Your Ref: OWPC7262
Our Ref: EP/120/15/HH 11-09-2015
Please ask for:
Mrs A Gardner

Remodelling & extensions
Hascombe 33 Tamarisk Way East Preston

Thank you for your internet representation made on 26th October 2015 which has been recorded as '**an objection**' with the comments as follows:

East Facing Elevation

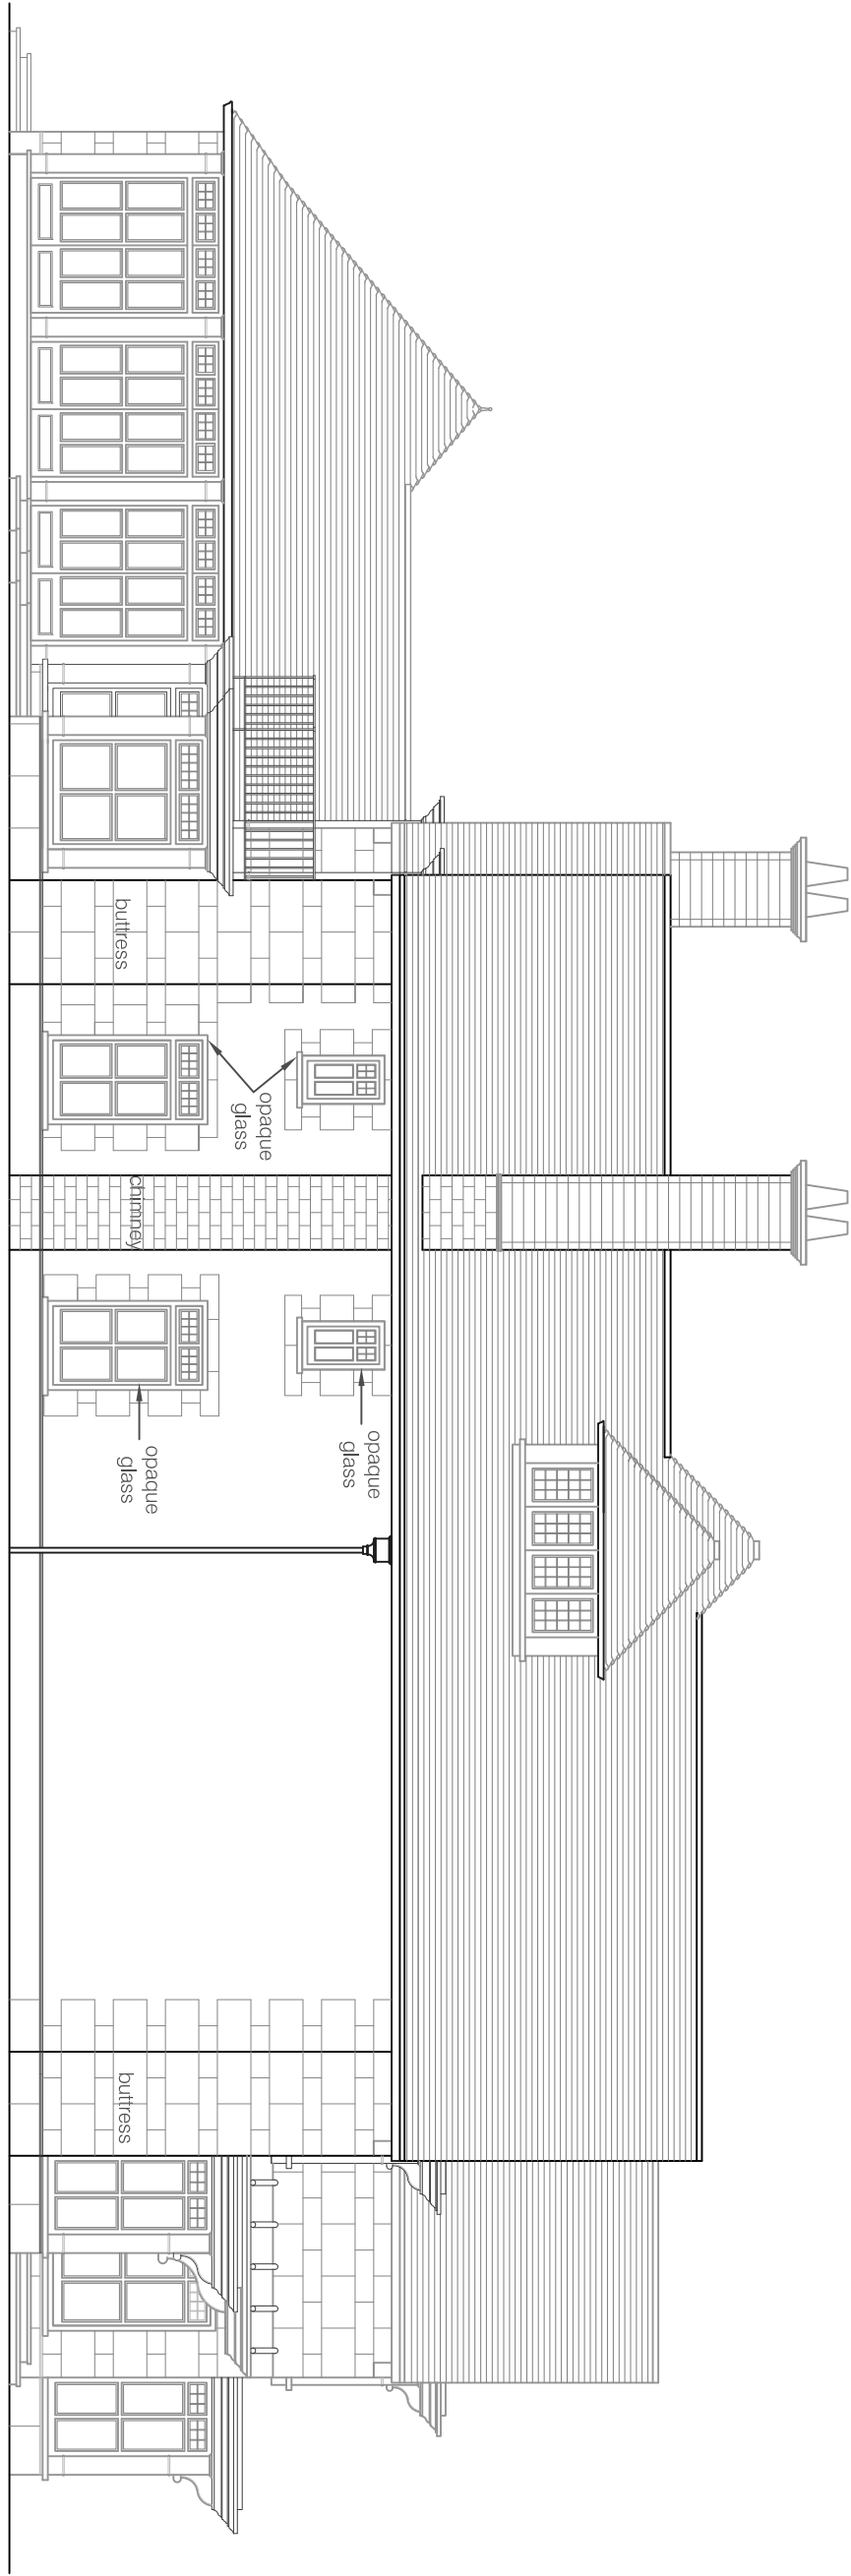
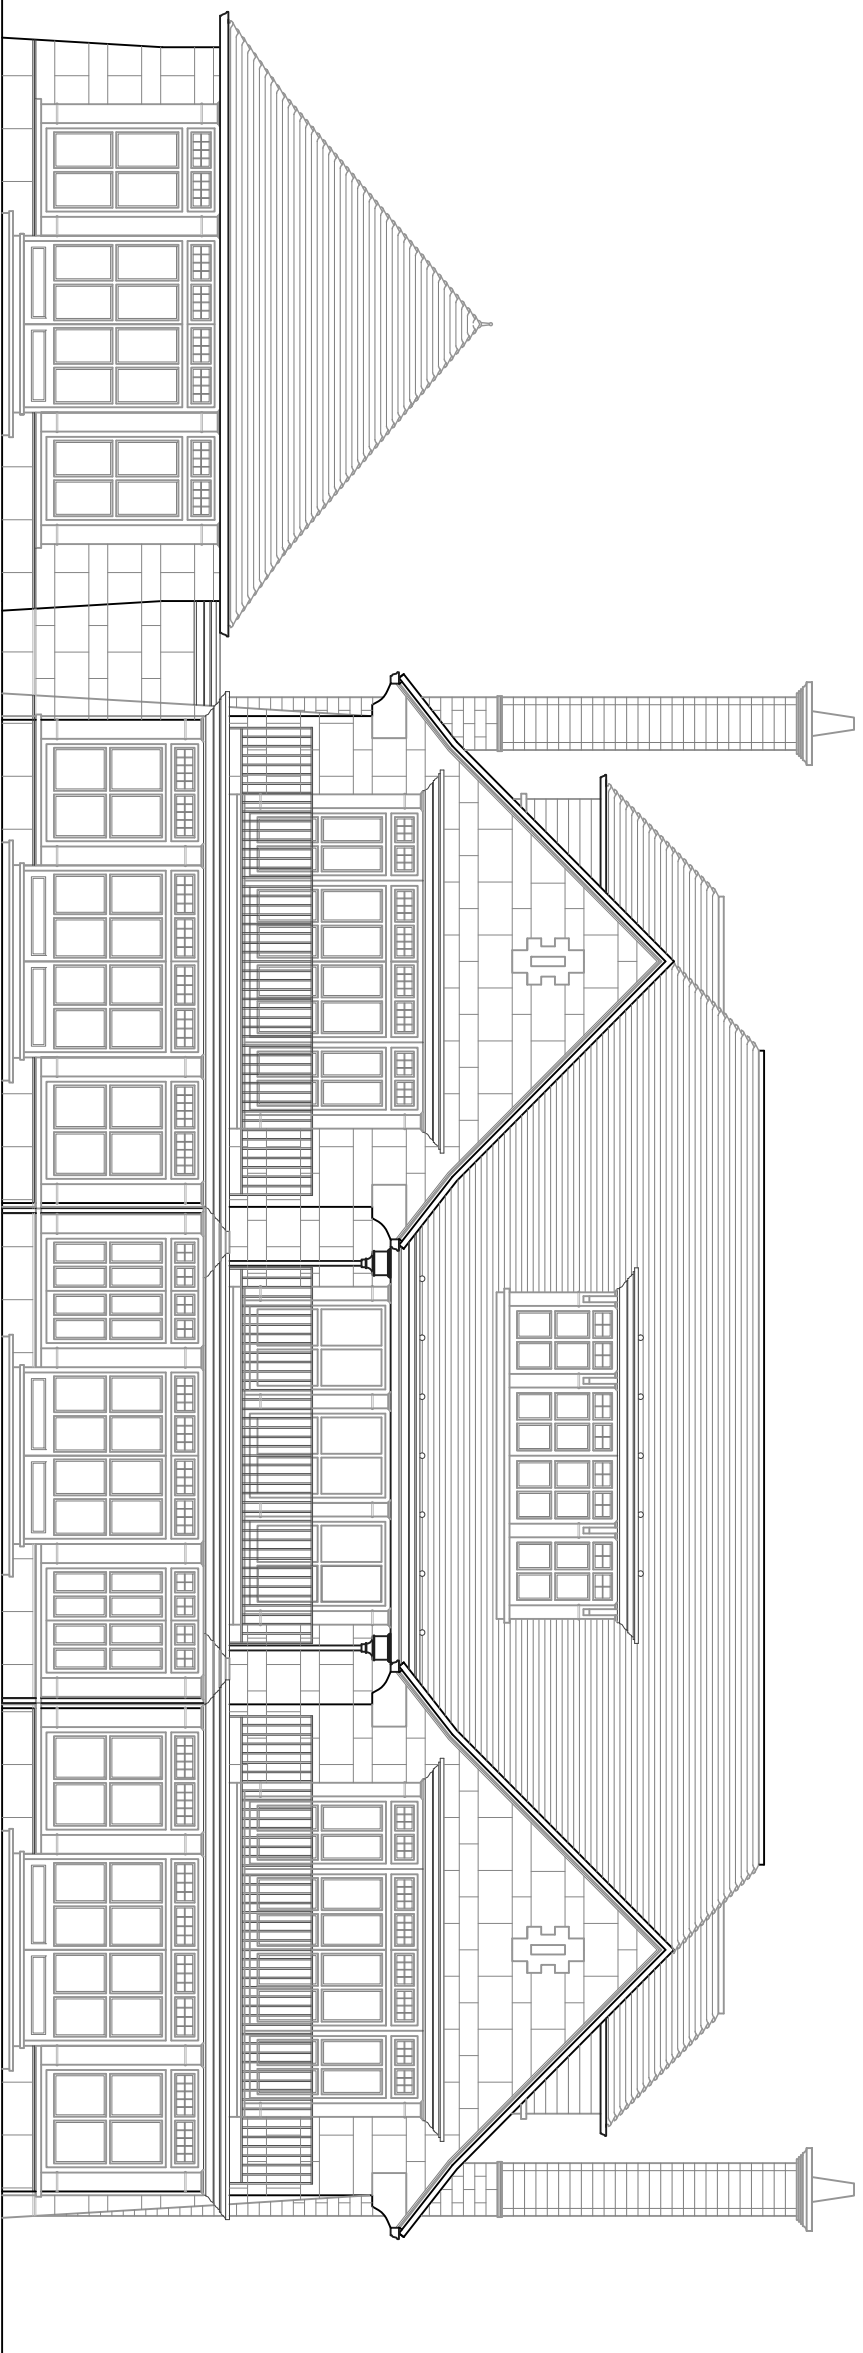
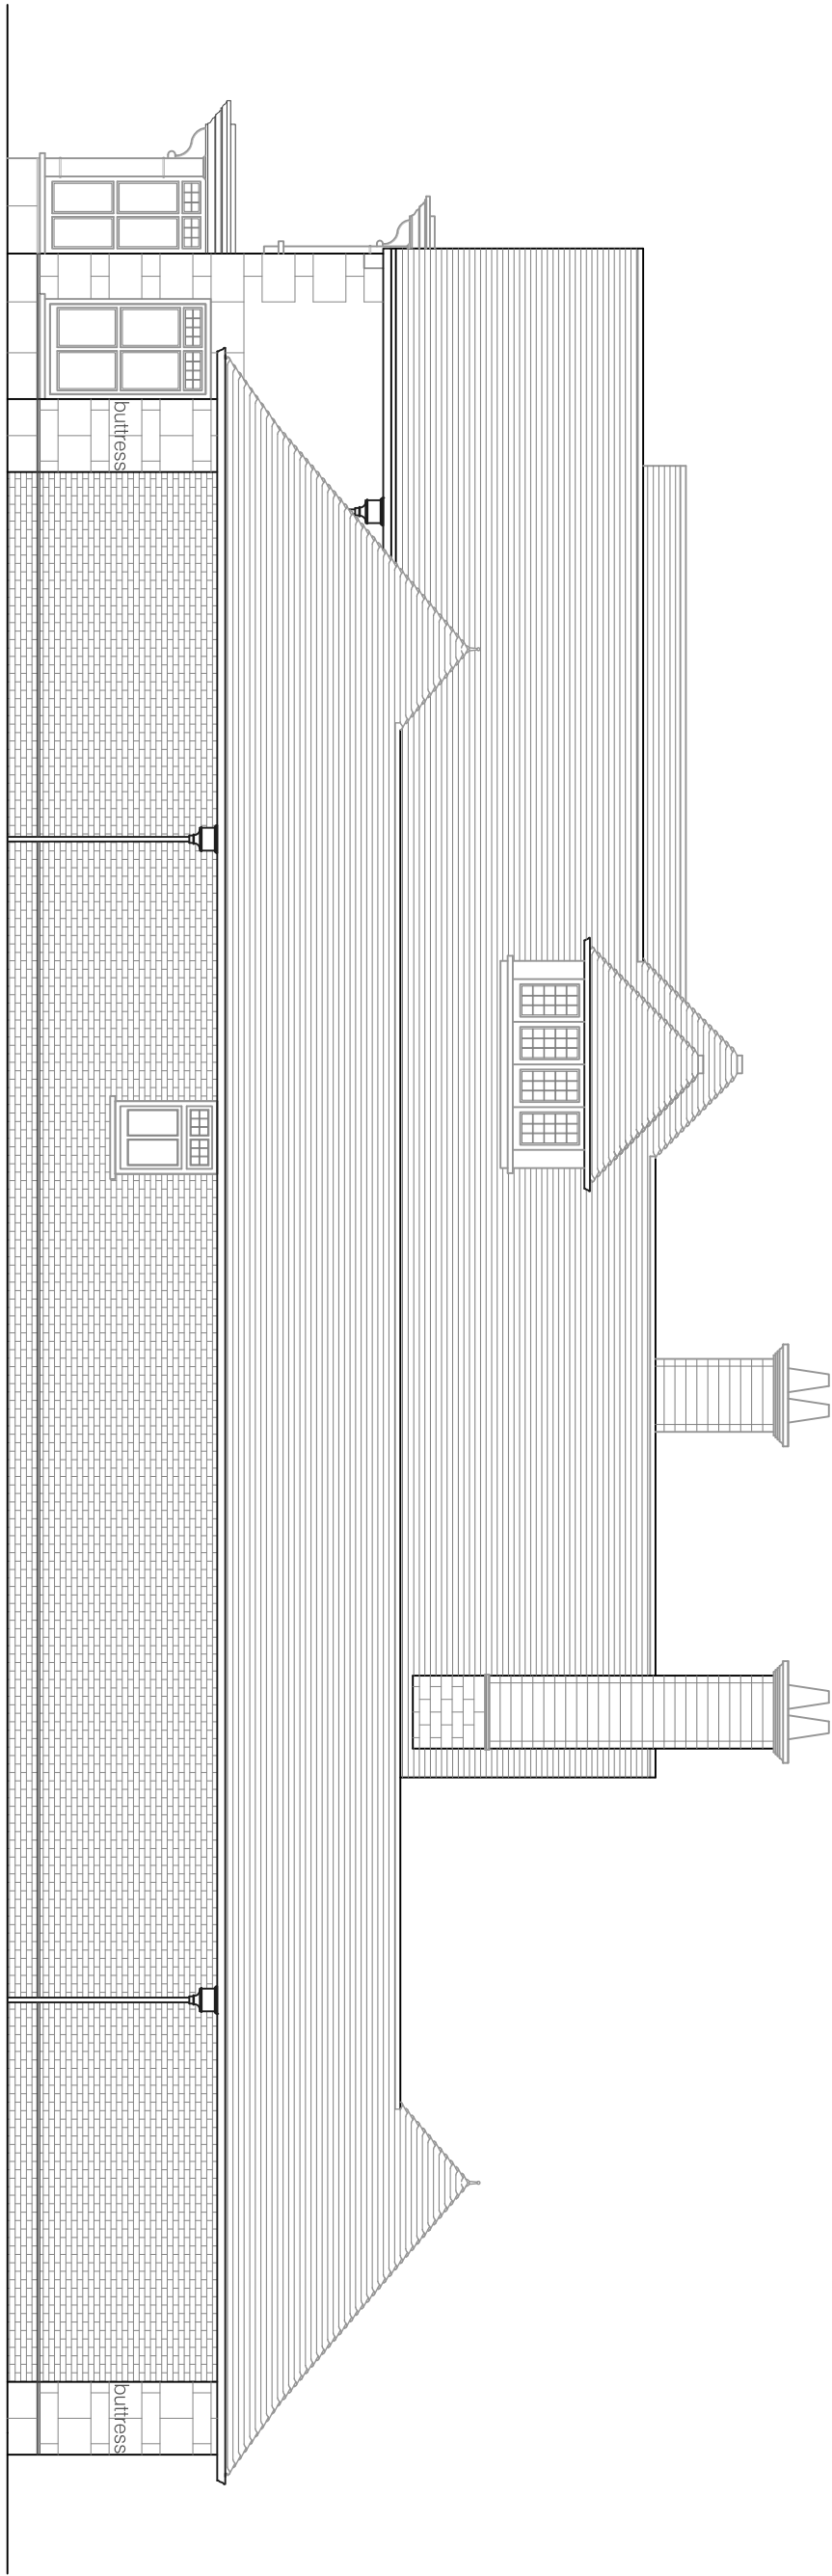
I also assume under building regulations the plant room proposed above the steam room / shower room will need to be ventilated and I question how this will be done as presently no extraction or ventilation equipment is shown on the elevations.

The applicant's assertion that "the only change in terms of scale and mass is the pitched roof over the side garage" is factually incorrect. It is evident for all to see from the plans provided, particularly the side elevations, the dramatic increase in the built area.
